**ANGEL PLACE  
LEVEL 8, 123 PITT STREET  
SYDNEY NSW 2000**

18 November 2021

## **SSD-10831778 – SYDNEY CHILDREN'S HOSPITAL STAGE 1 AND CHILDREN'S COMPREHENSIVE CANCER CENTRE- RESPONSE TO REQUEST FOR FURTHER INFORMATION**

This letter has been prepared by Urbis on behalf of Health Infrastructure New South Wales (HI), the applicant for the Sydney Children's Hospital Stage 1 and Children's Comprehensive Cancer Centre (SCH1/ CCCC) SSD-10831778. It responds to matters raised by Randwick City Council (Council) in their letter dated 25 October 2021.

High Street Interface

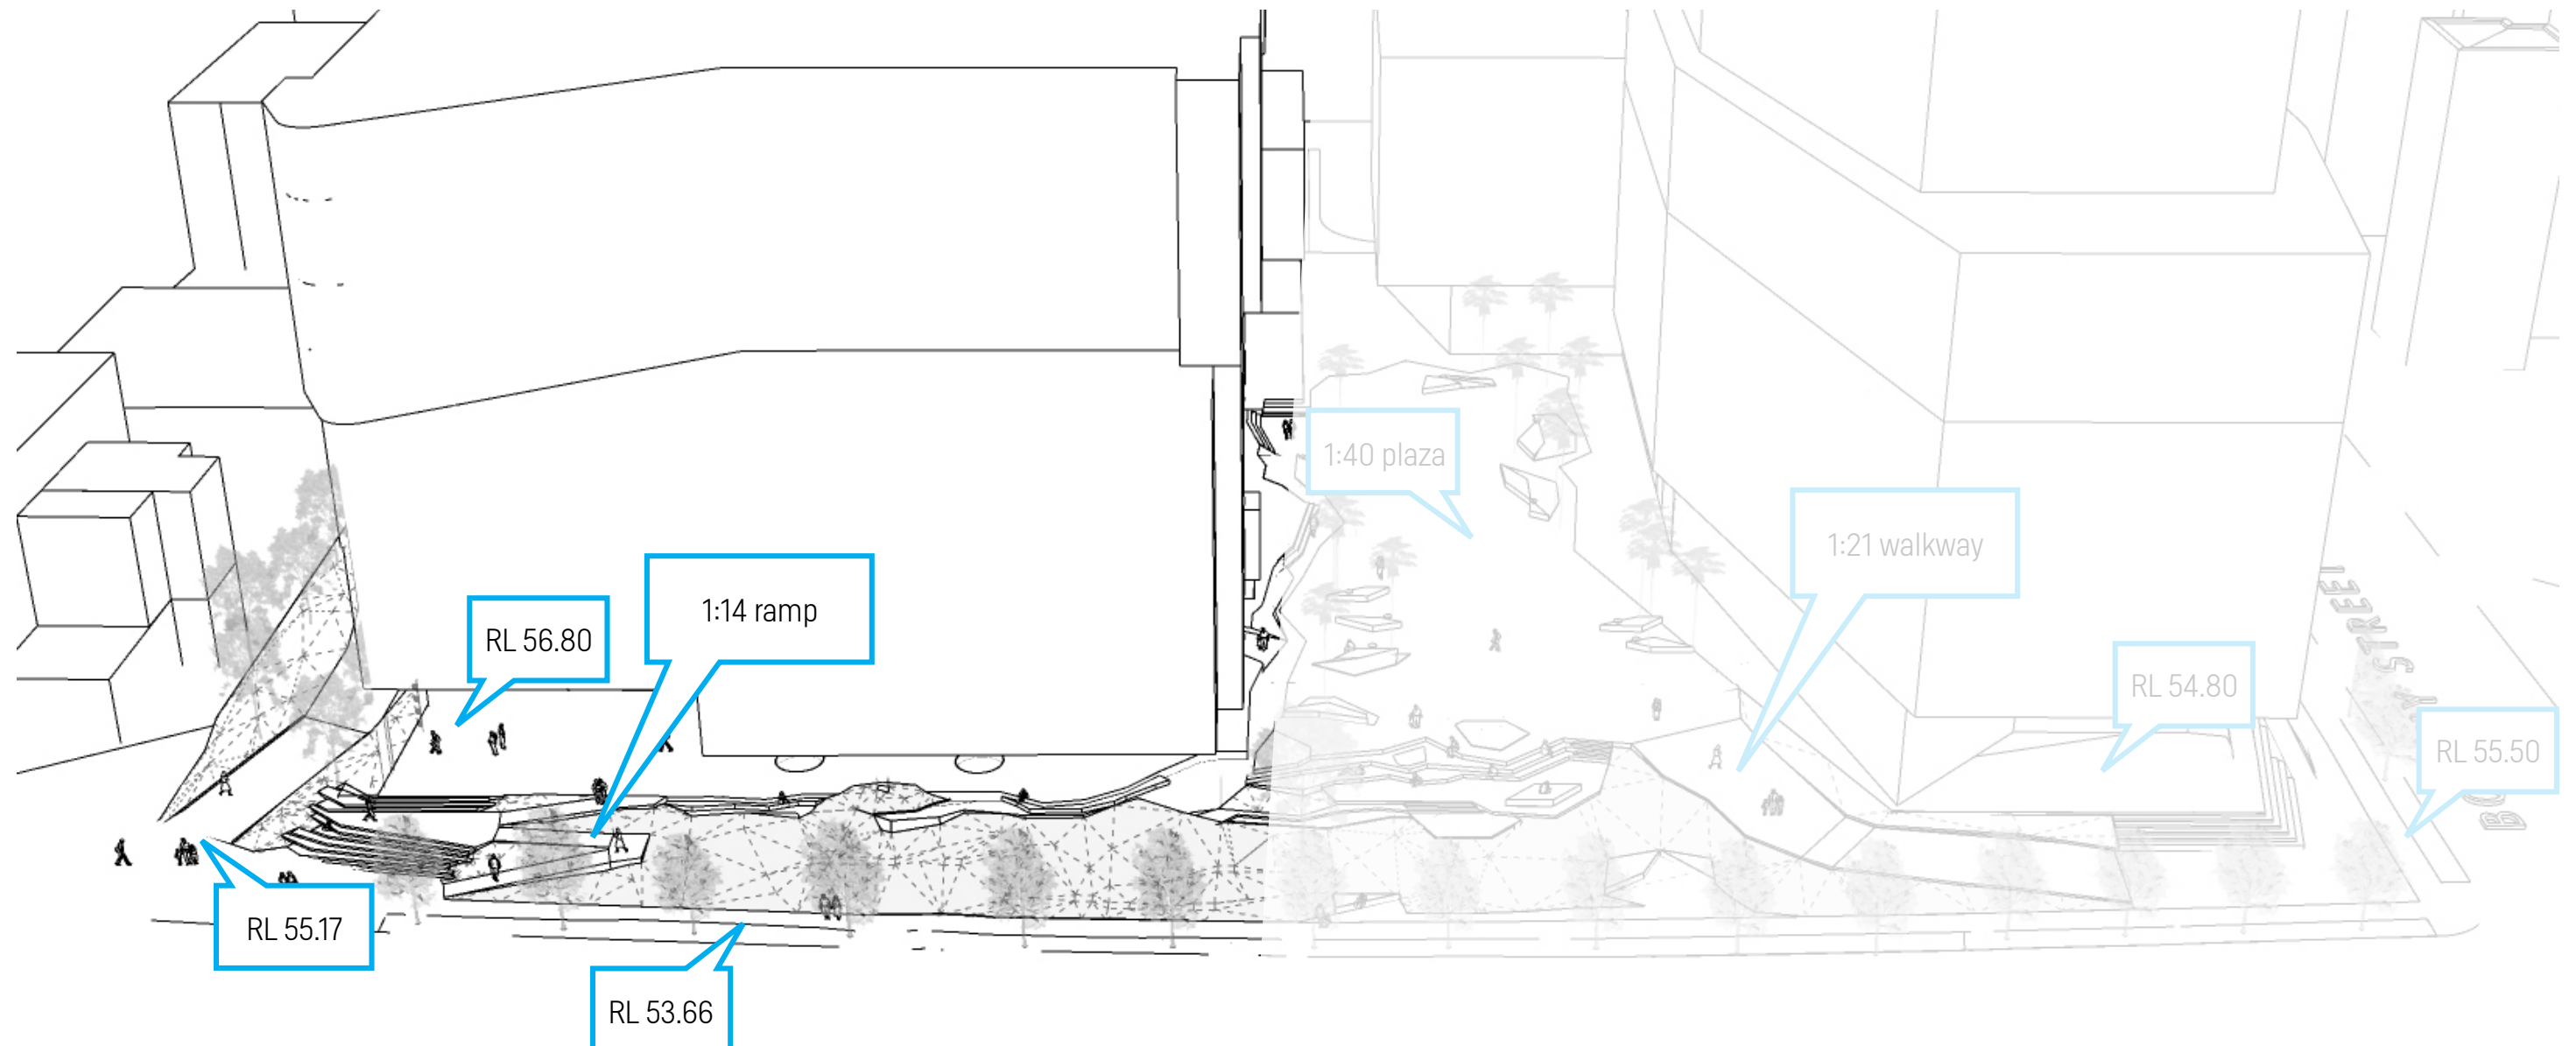
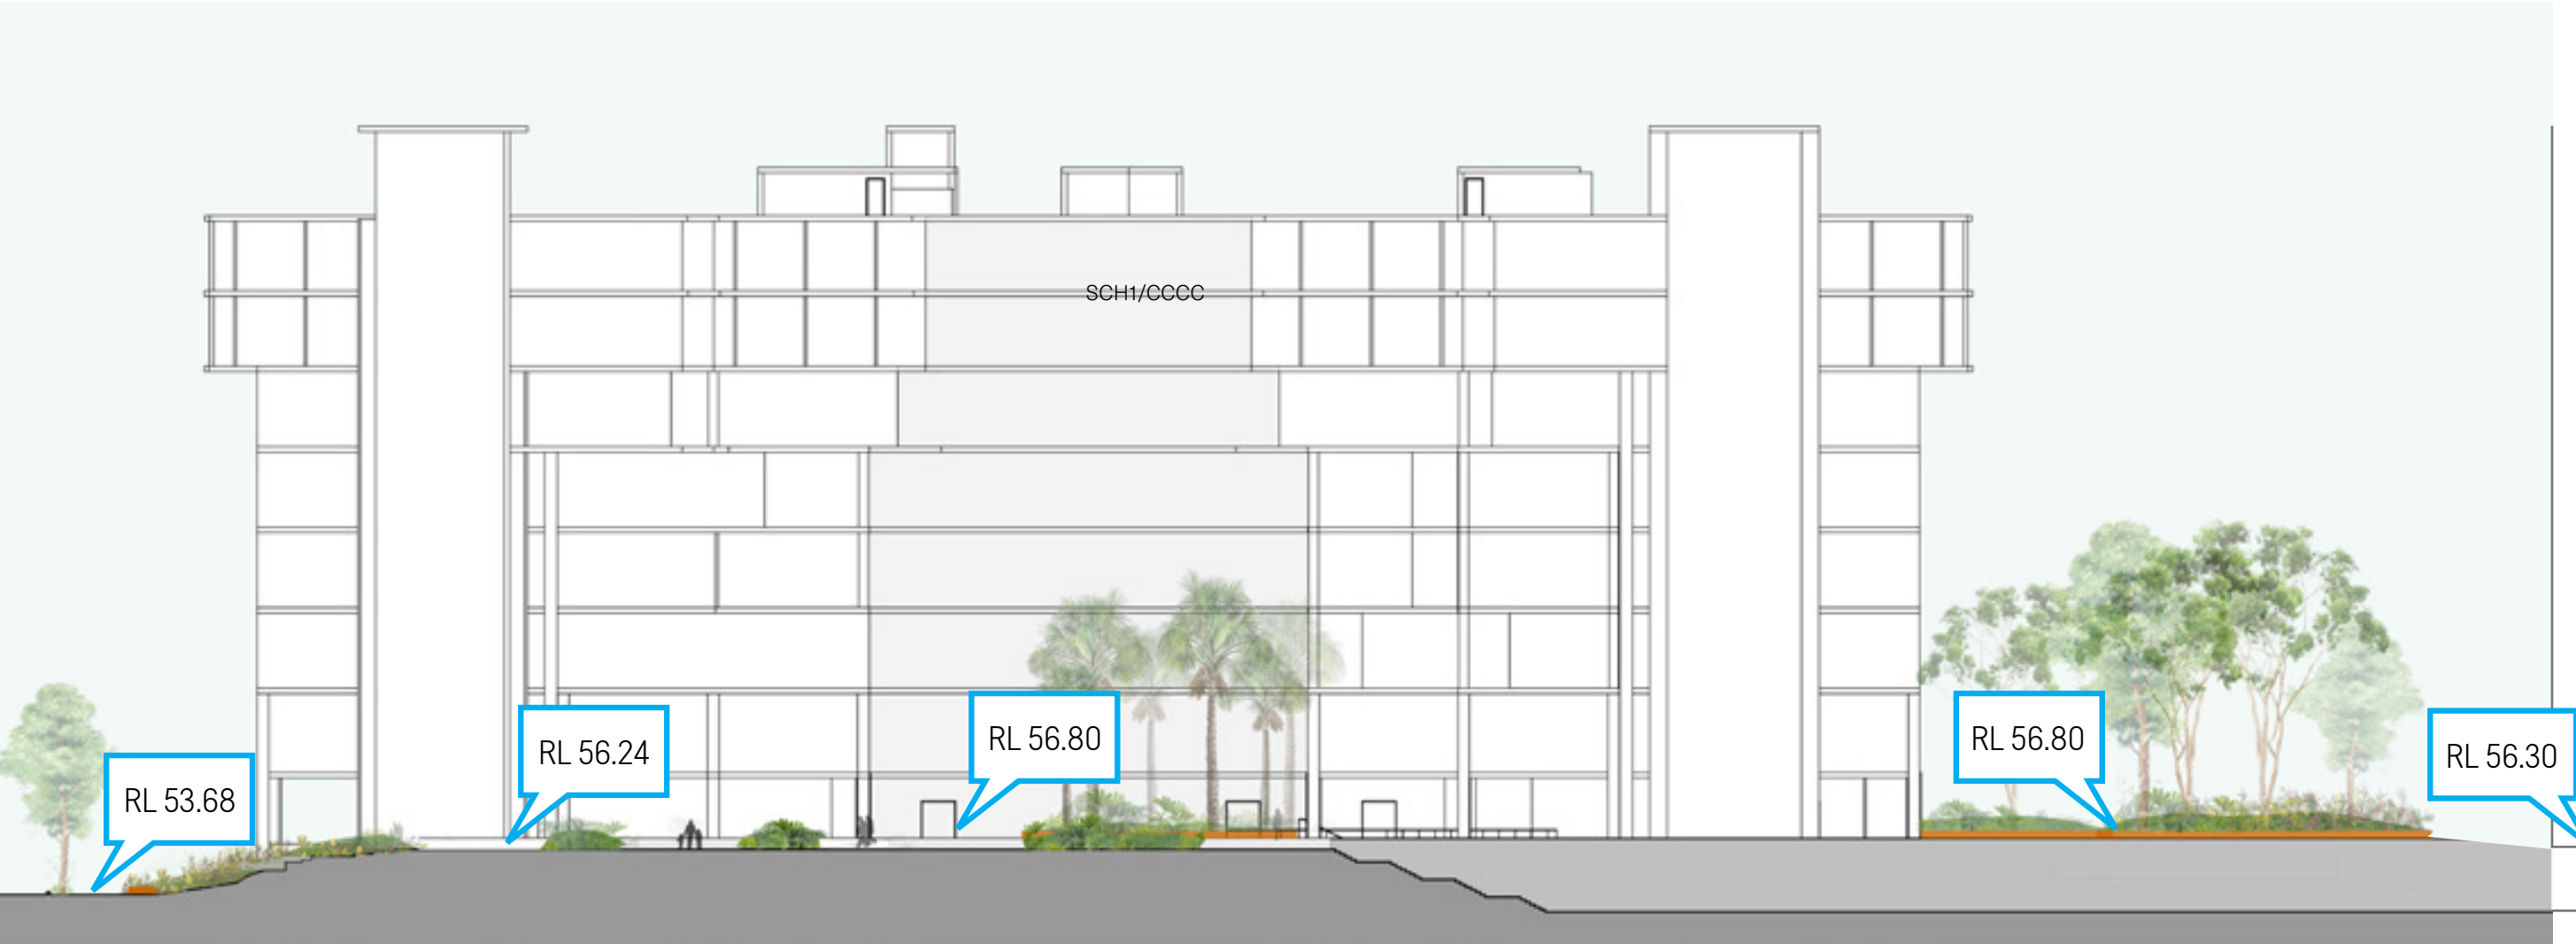
Council's position is that a 3m minimum width footpath to High Street is required deliver a shared pedestrian/ bicycle path along the SCH1/CCCC and HTH project frontages.

Council has prepared a draft sketch for consideration showing how this might be achieved – refer **Figure 1**.

As detailed in the RTS, the widening of the footpath would result in a sub-optimal design solution as:

- it would require the introduction of a 650mm retaining wall with negative impacts on views into the site. This is an important project principle that reduces boundary lines and promotes an inviting and equitable key entry.

- there needs to be physical separation between pedestrians and the existing stormwater infrastructure. This is currently provided by a small planted buffer. Widening of the footpath will increase the risk of conflict. Stormwater pits protrude above the ground level which would prevent a clear unobstructed path and present a safety risk.

- it would diminish the landscape outcome due to the removal of available landscaped area from the design. It is noted that the alternative Council sketch concept shows large trees on the southern boundary of the footpath. Due to the existing services in the area and subsequent soil depths in this location this would not be able to be achieved.

HI has discussed the proposed footpath design with UNSW, and the shared view is that retention of the existing footpath design for SCH1/CCCC and the HTH will provide a consistent approach and the optimal public domain outcome.
